Recommendation Report for Planning Permission for Works or Extension to a Dwelling

REF NO: AW/384/21/HH

LOCATION: 12 Aldwick Place
Aldwick
PO21 4AB

PROPOSAL: Erection of side infill extension to create garage, front porch extension and conversion of existing garage to habitable use.

Scale 1:50 on A3

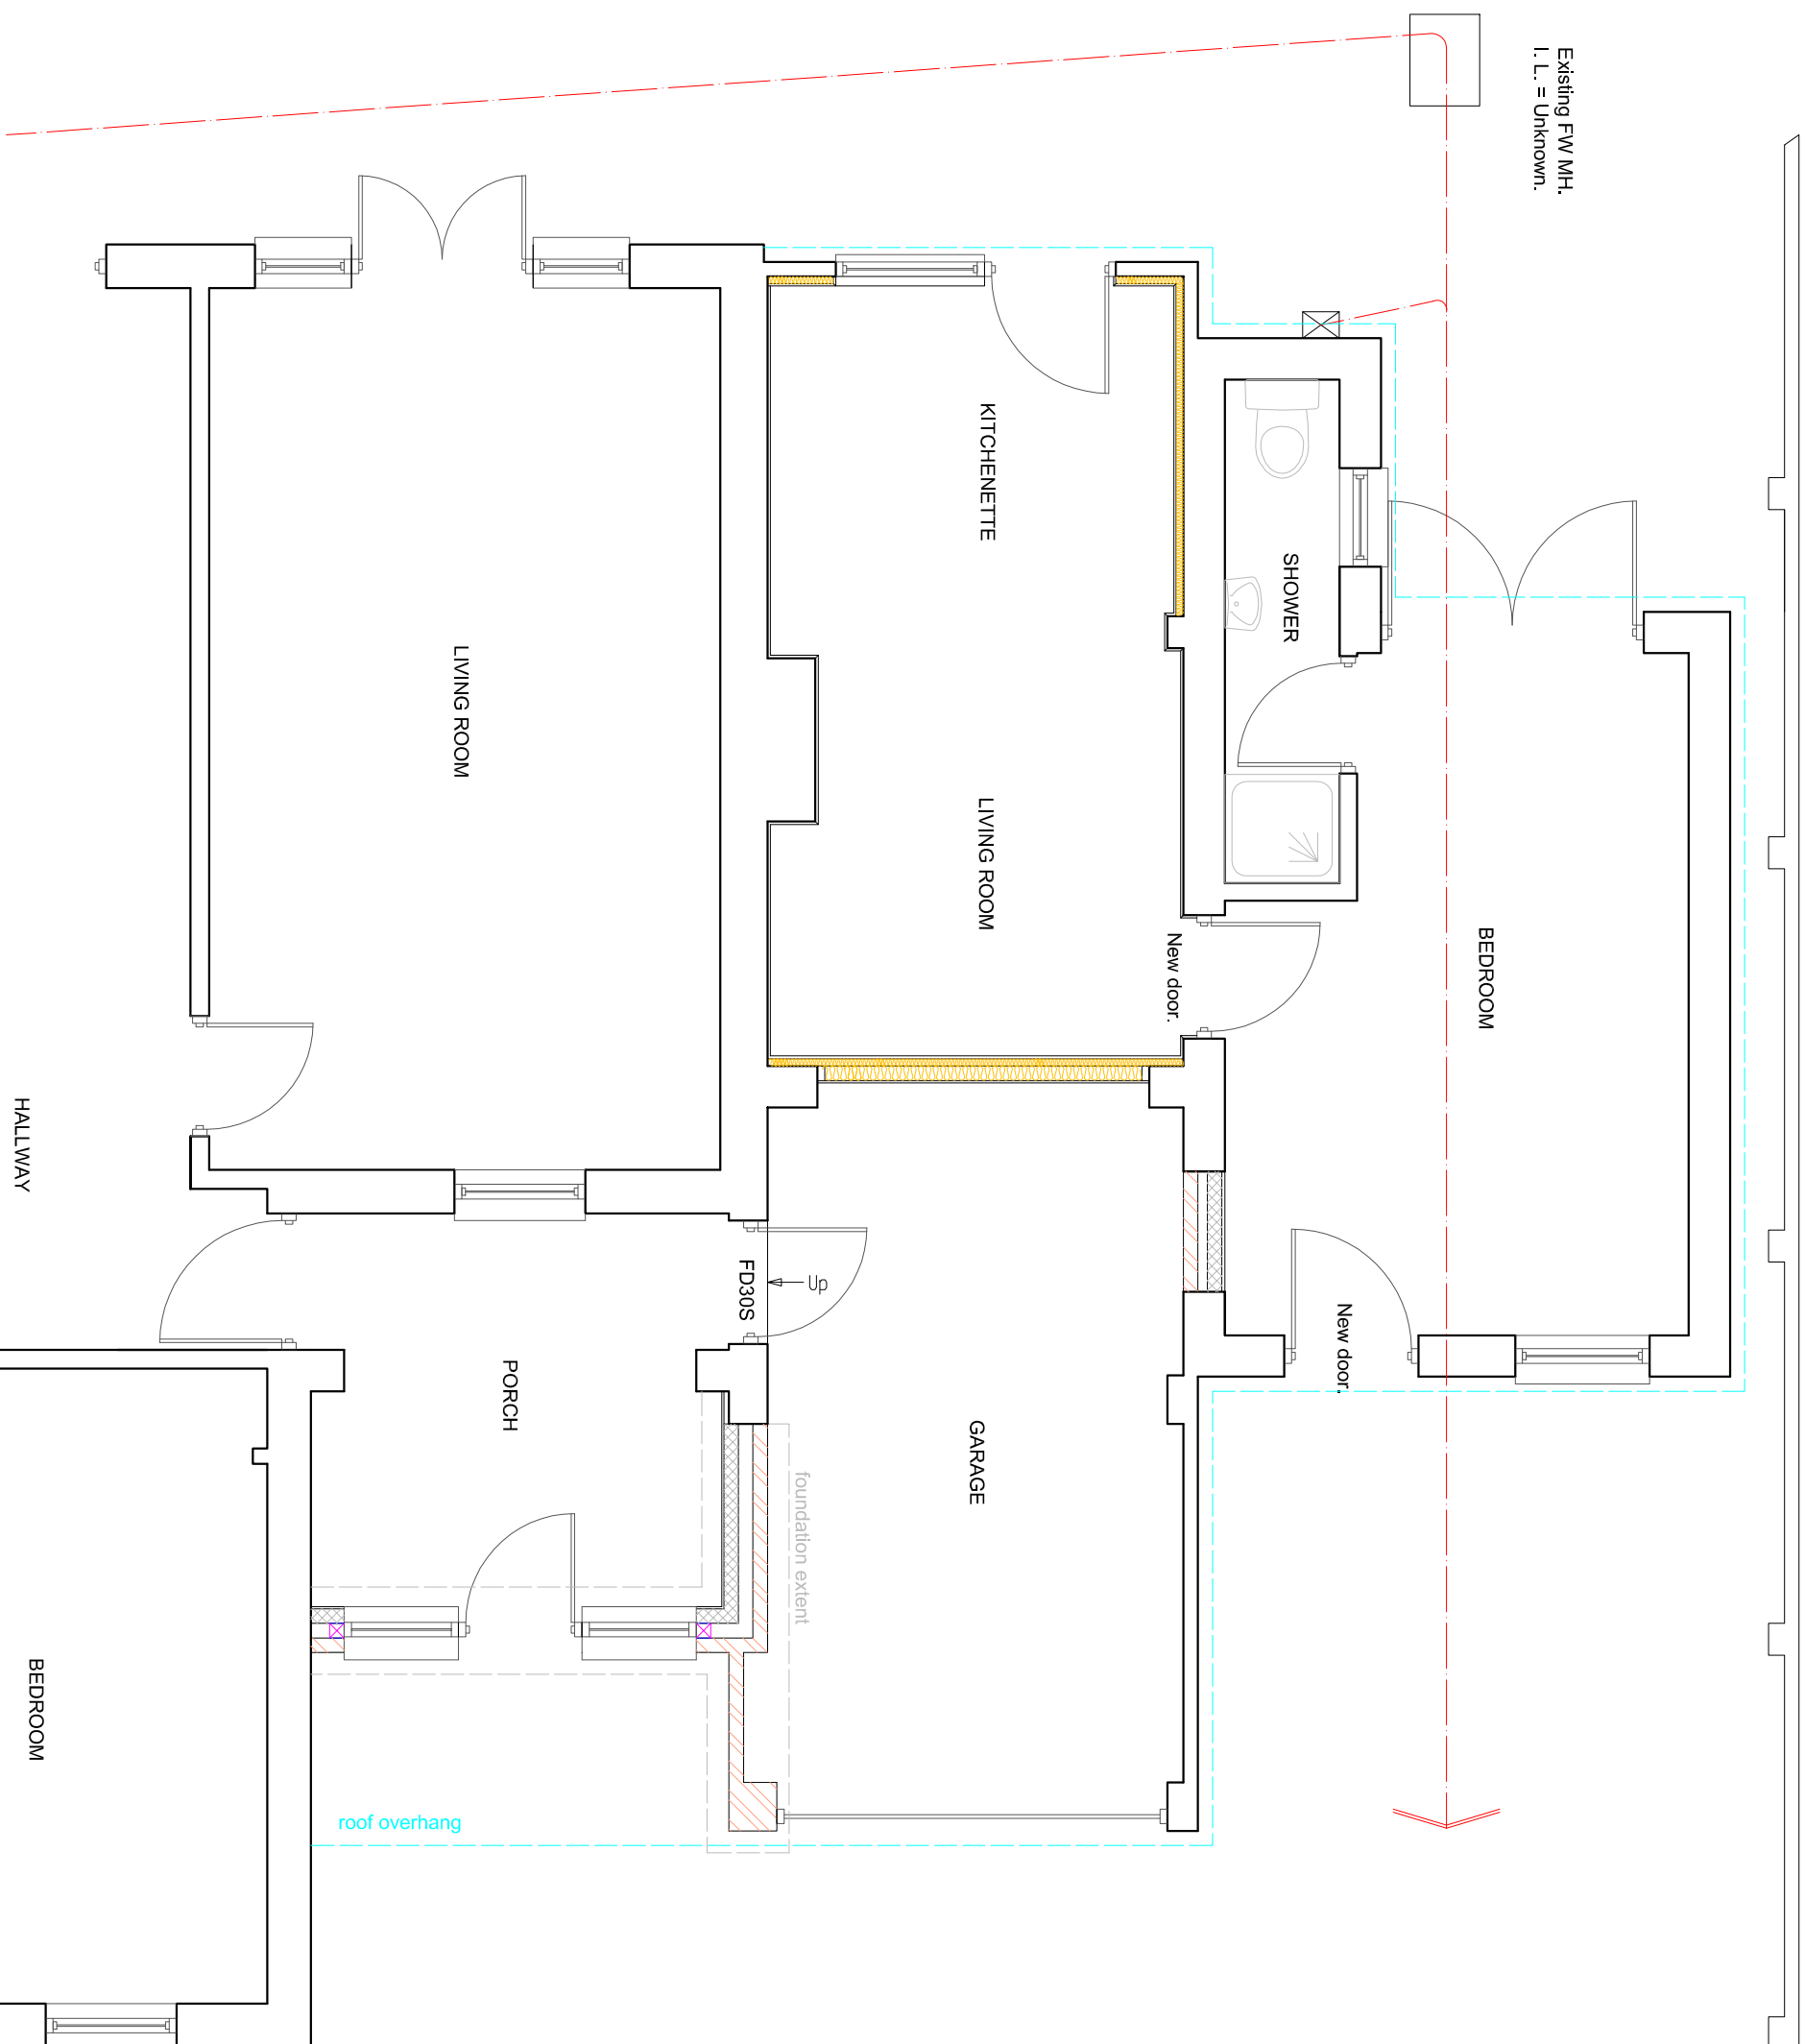
of the property. The proposal retains 4.3m from the western boundary and has no direct distance to the eastern boundary. As the property is at the end of the row, it has no neighbouring properties to the west that may be at risk of harm to residential amenity. The proposal is therefore not considered to result in adverse overbearing or overshadowing and is in accord with D DM4 of the Arun Local Plan.

PROPOSED ELEVATIONS

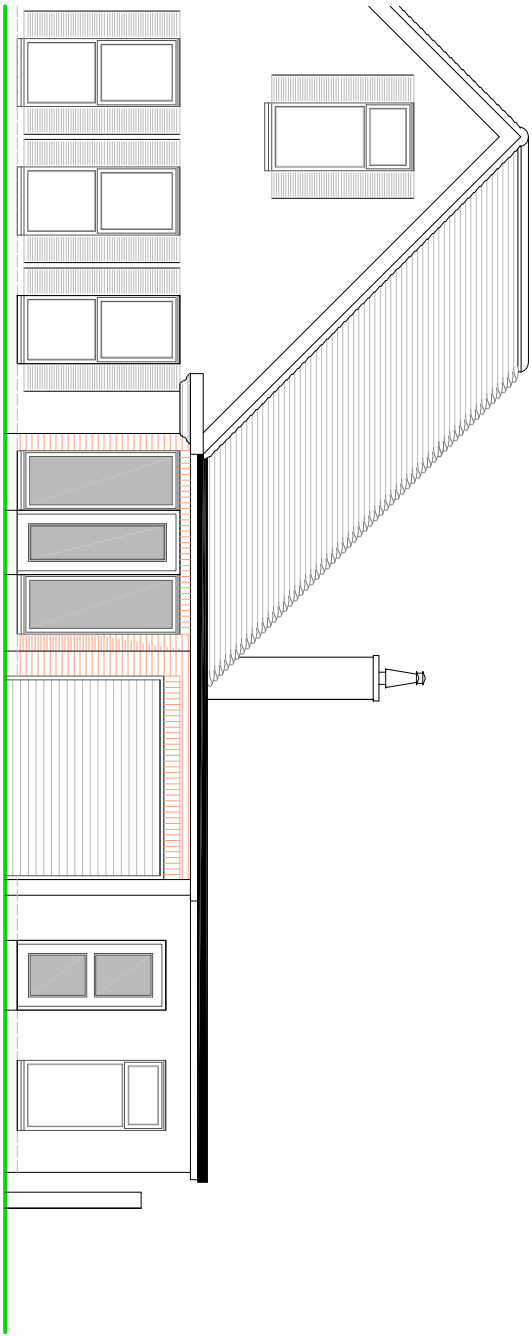
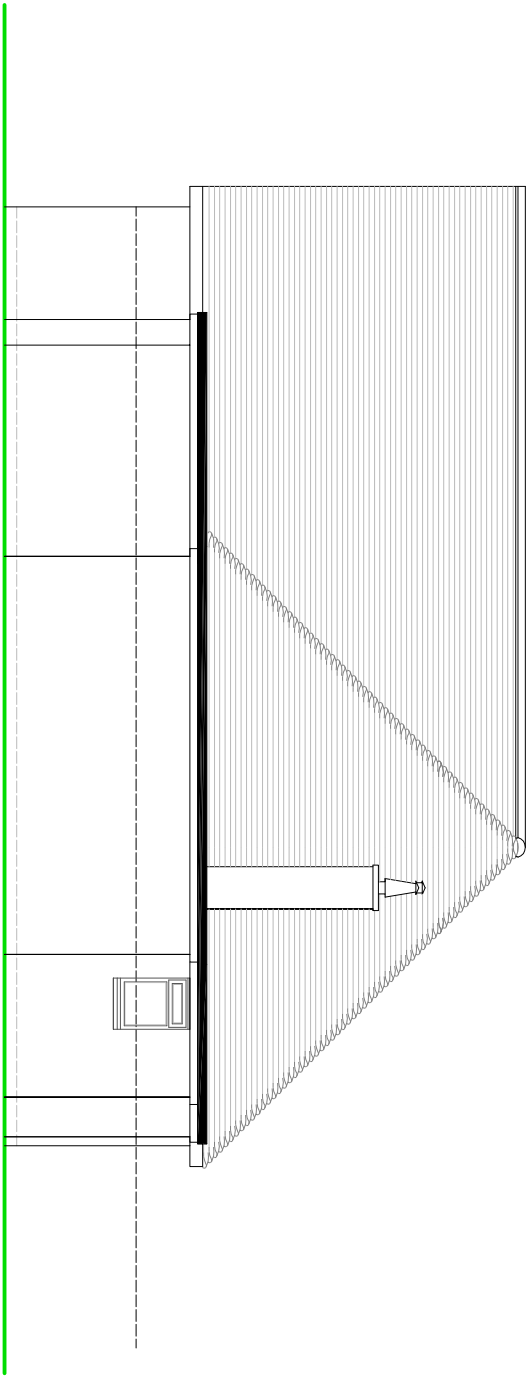
The porch will have a width of 2.9m and depth of 1.8m. It will have a flat roof, as will the proposed garage, matching the existing porch and carport. The garage will not change the height or footings of the existing carport, but will enclose the structure with a new wall to the east and garage door to the front. The new wall will measure 2.8m, extending 1m further than the porch. Despite the main building having a pitched roof, the flat roofed porch and garage is not considered to have an unduly harmful impact upon its visual appearance and will integrate sympathetically with the existing side extension and garage. The extension retains a distance of 16.1m from the front boundary and will be visible from the street scene, although some views from the wider area may be restricted by trees situated to the front and side of the property. The street has a set composition, made up of detached properties with very similar design styles. As the works are minimal and have little impact on the visual appearance of the property, they are considered to be in keeping with the general character of the area.

The extension will be to the front of the property. It is single storey and will have a flat roof with a height of 2.7m. This will match the height of the existing side extension, ensuring minimal impact on the roof line

The proposal features the addition of a new door to the existing side extension, a garage door and a front access door to the porch, with two windows on either side. These features all face to the front of the property and do not overlook any neighbouring properties. Given their scale and location, they are not considered to result in adverse overlooking, overshadowing or overbearing and have limited impact upon residential amenity.
